CONSULTATION RESPONSE MATRIX

LAND EAST OF TYE LANE, WALBERTON

ON BEHALF OF: LINDEN HOMES (SOUTH) AND WATES DEVELOPMENTS

PRIVATE MANHOLE TYPE A
(DEPTH FROM COVER LEVEL TO SOFFIT OF PIPE 3.0-6.0m)

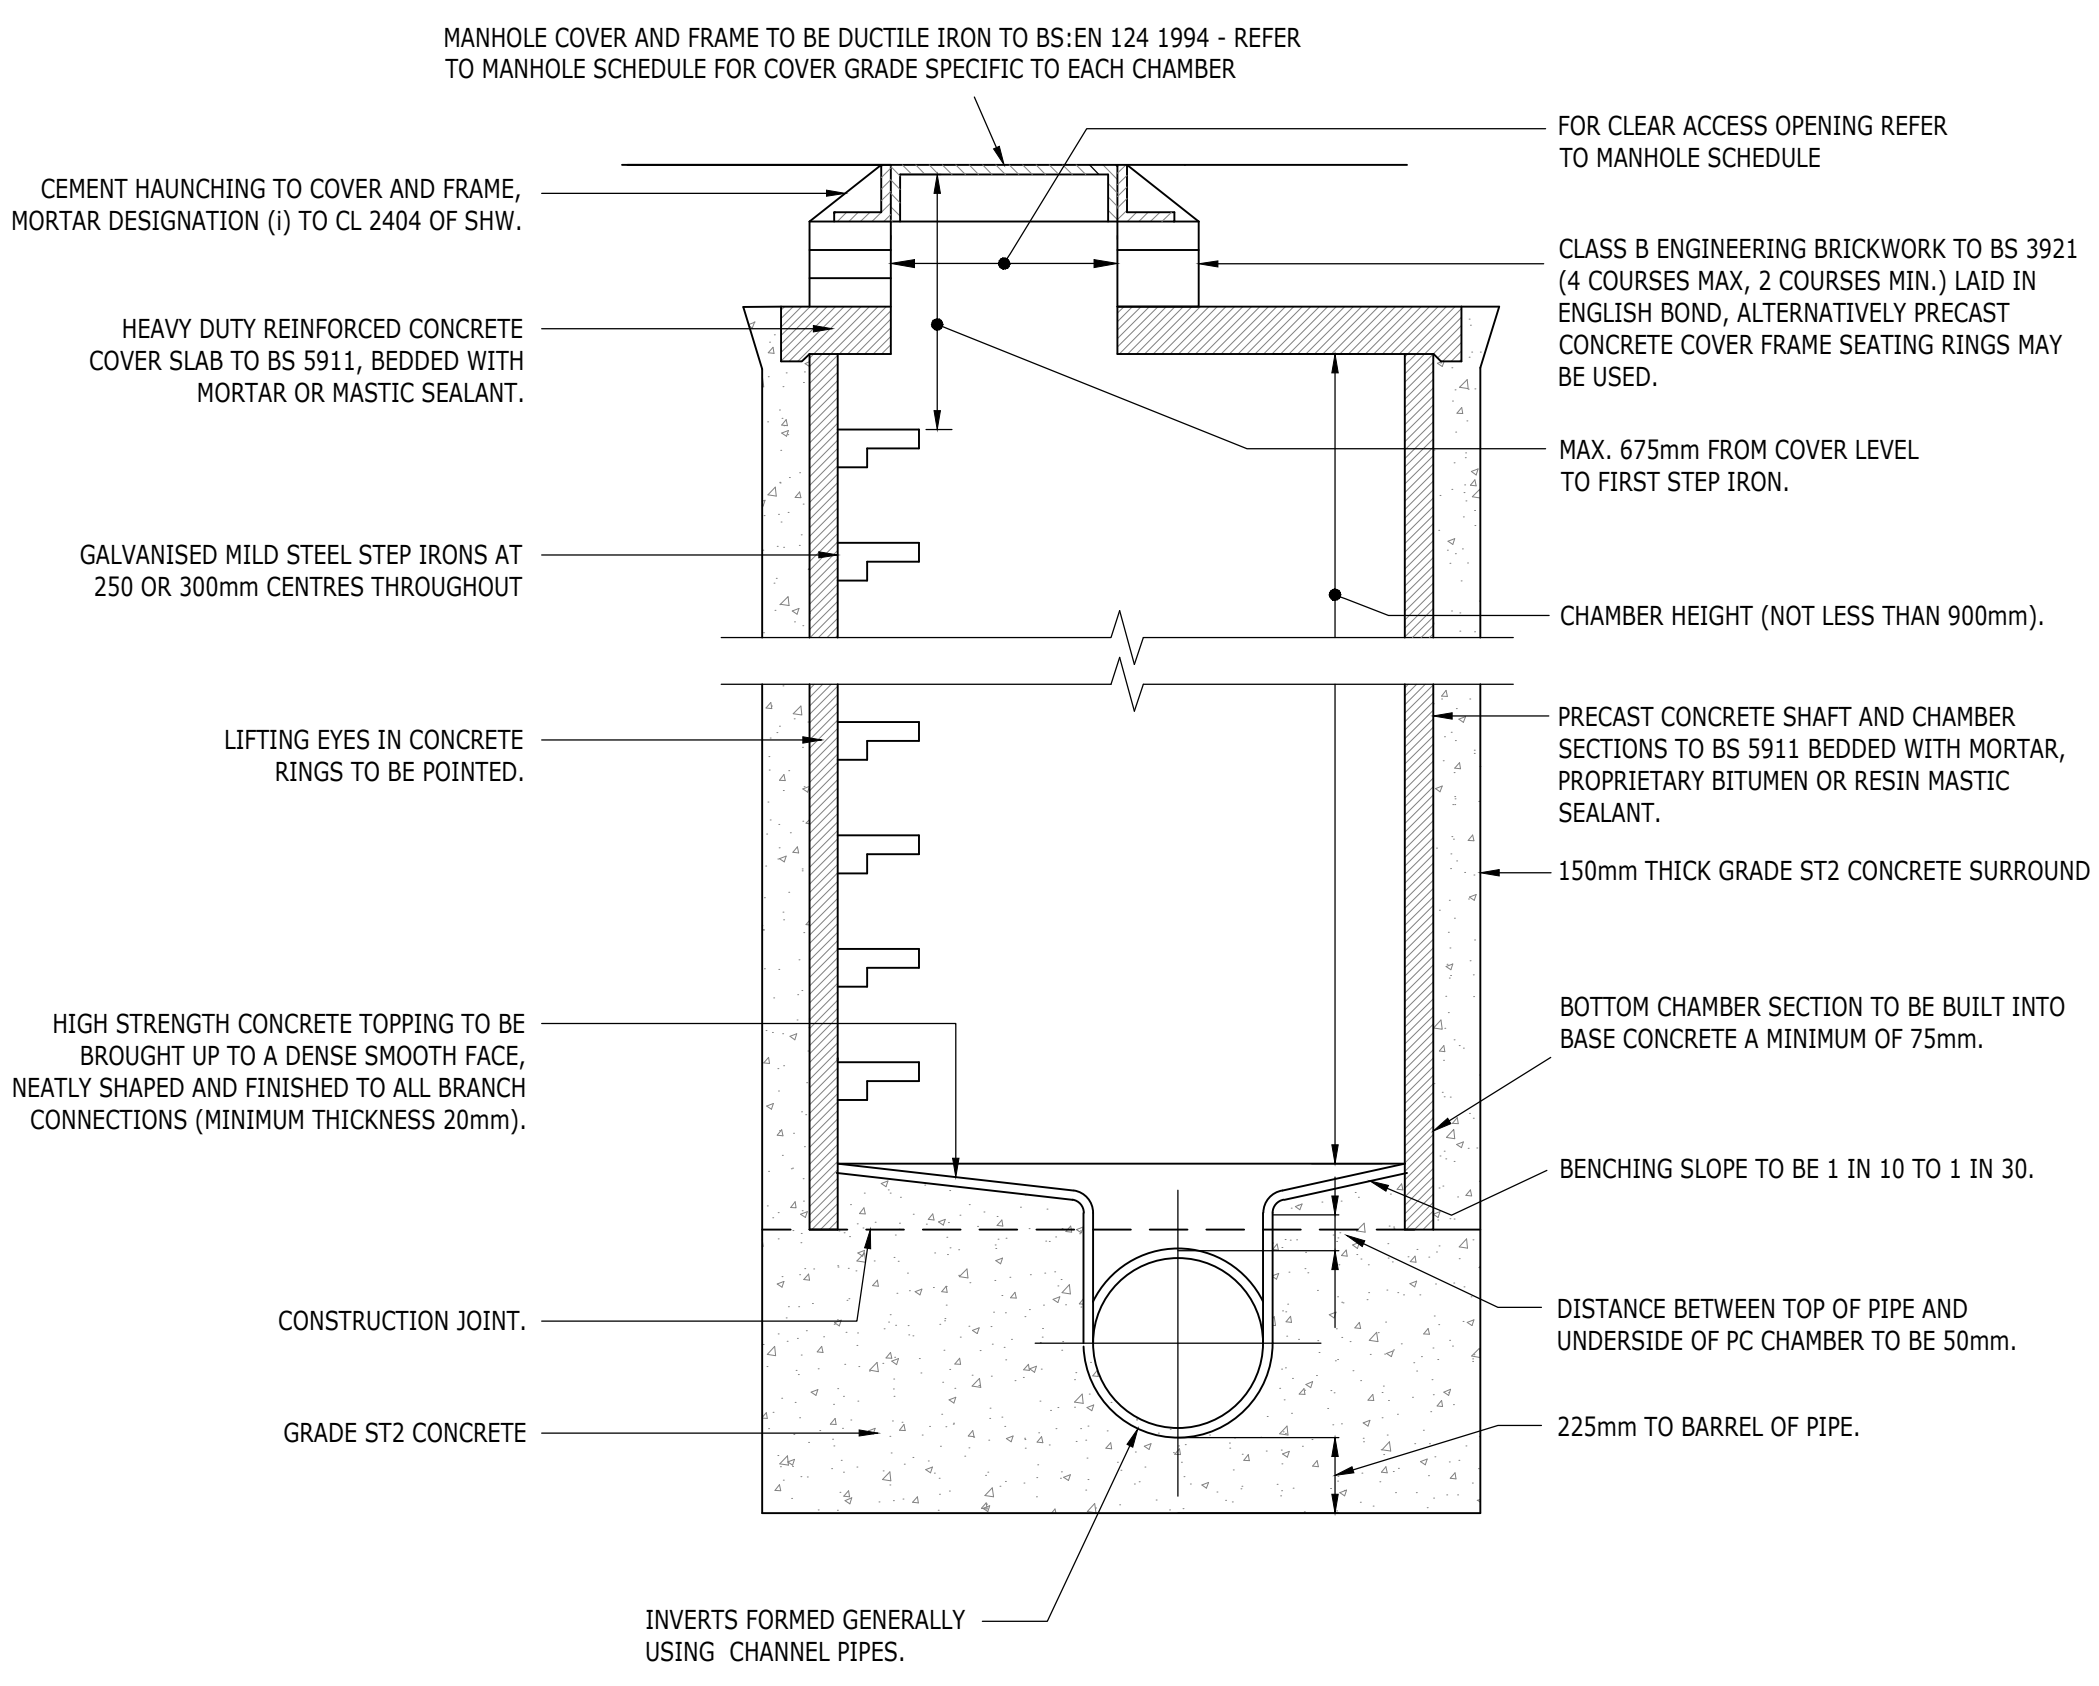
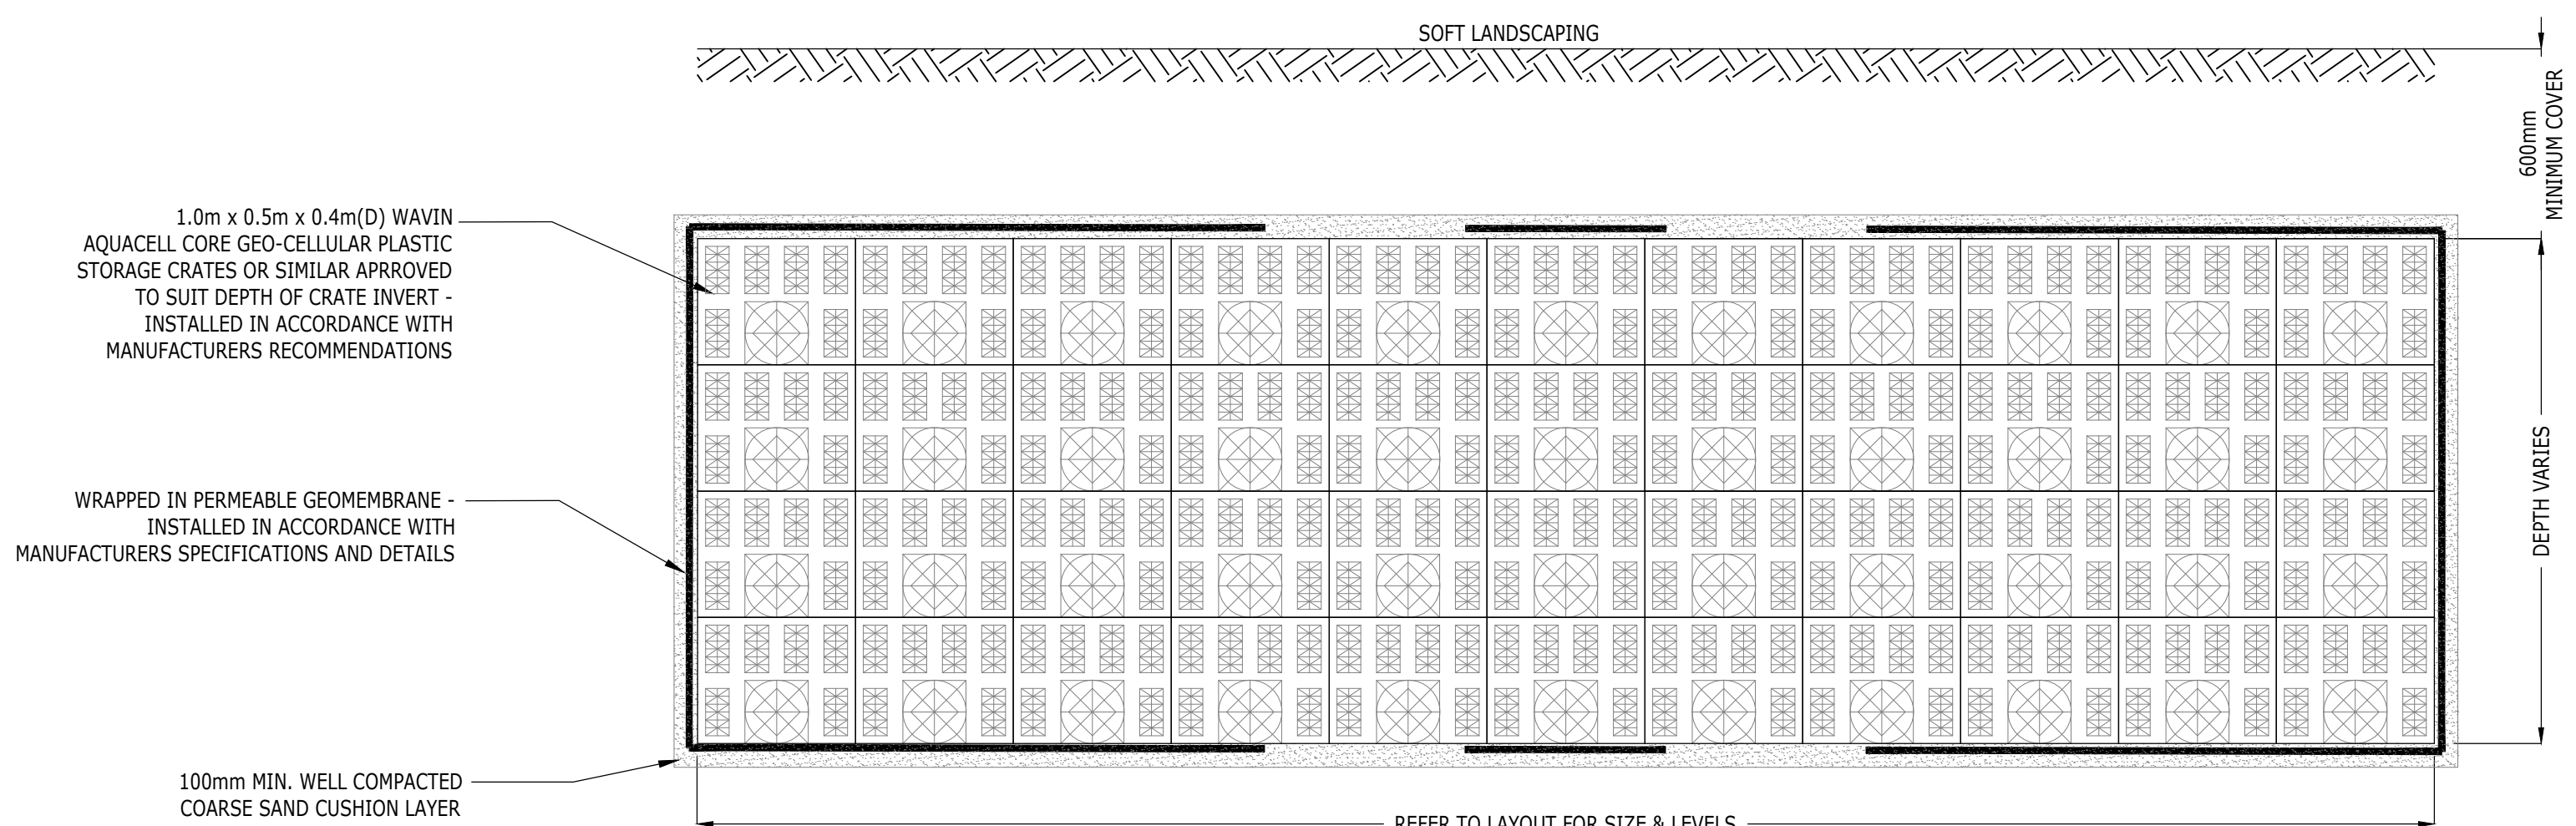
- Groundwater monitoring results and infiltration test results, including depths of testing. - Location plan showing monitoring and testing location. - Full calculations demonstrating that the 1 in 100 year plus 40% climate change event can be accommodated. - Calculations detailing that minimum half drain time requirements are met. - Safety factors are applied to design in line with CIRIA requirements Drainage layout plans, to include: - All surface water drainage pipes labelled with; diameters, falls and invert levels. - All infiltrating and attenuating structures (including permeable paving) labelled with; dimensions invert and cover levels. - All manholes labelled with; cover levels, invert levels, cover type detailed. - All silt traps clearly labelled with sump depths. - Control structures with outflow rates and invert levels. - Construction detail drawing, to include (if specified in scheme): - pipe bed and surround - Infiltrating structures - Manholes - Catchpits/silt traps - Control devices - Permeable paving - Headwalls - Exceedance flow routes	Available, including for the winter months as requested. These are submitted with the revised pack. As above. We have carried out full hydraulic calcs and these will be submitted. They demonstrate that the above storm is accommodated within the system with no flooding. These are included in revised details and the figures are well within the required parameters. As standard, we have carried out our design with a safety factor of 2 which adheres to the above as there is no damage or inconvenience, i.e. the water does not flood from the basins. This is as per the current drainage plan, no update required. The revised plan have added the areas of each porous paving construction and also add a typical detail (to detail the depth) for said porous paving to the General Arrangement Plan. Plans now note that "all cover types are to be a suitable load class for their proposed loading". Key added to the plan that all highway and private swale network manholes are to be catchpits with a 300mm sump below IL. Added to the plan the controls with levels and sizes (orifice plates). as per sewers for adoption. as per detail already on drawing. as per sewers for adoption. as per local highway authority details. Added a typical orifice plate detail. as per typical detail added to General Arrangement Plan as per sewers for adoption. Added to plans
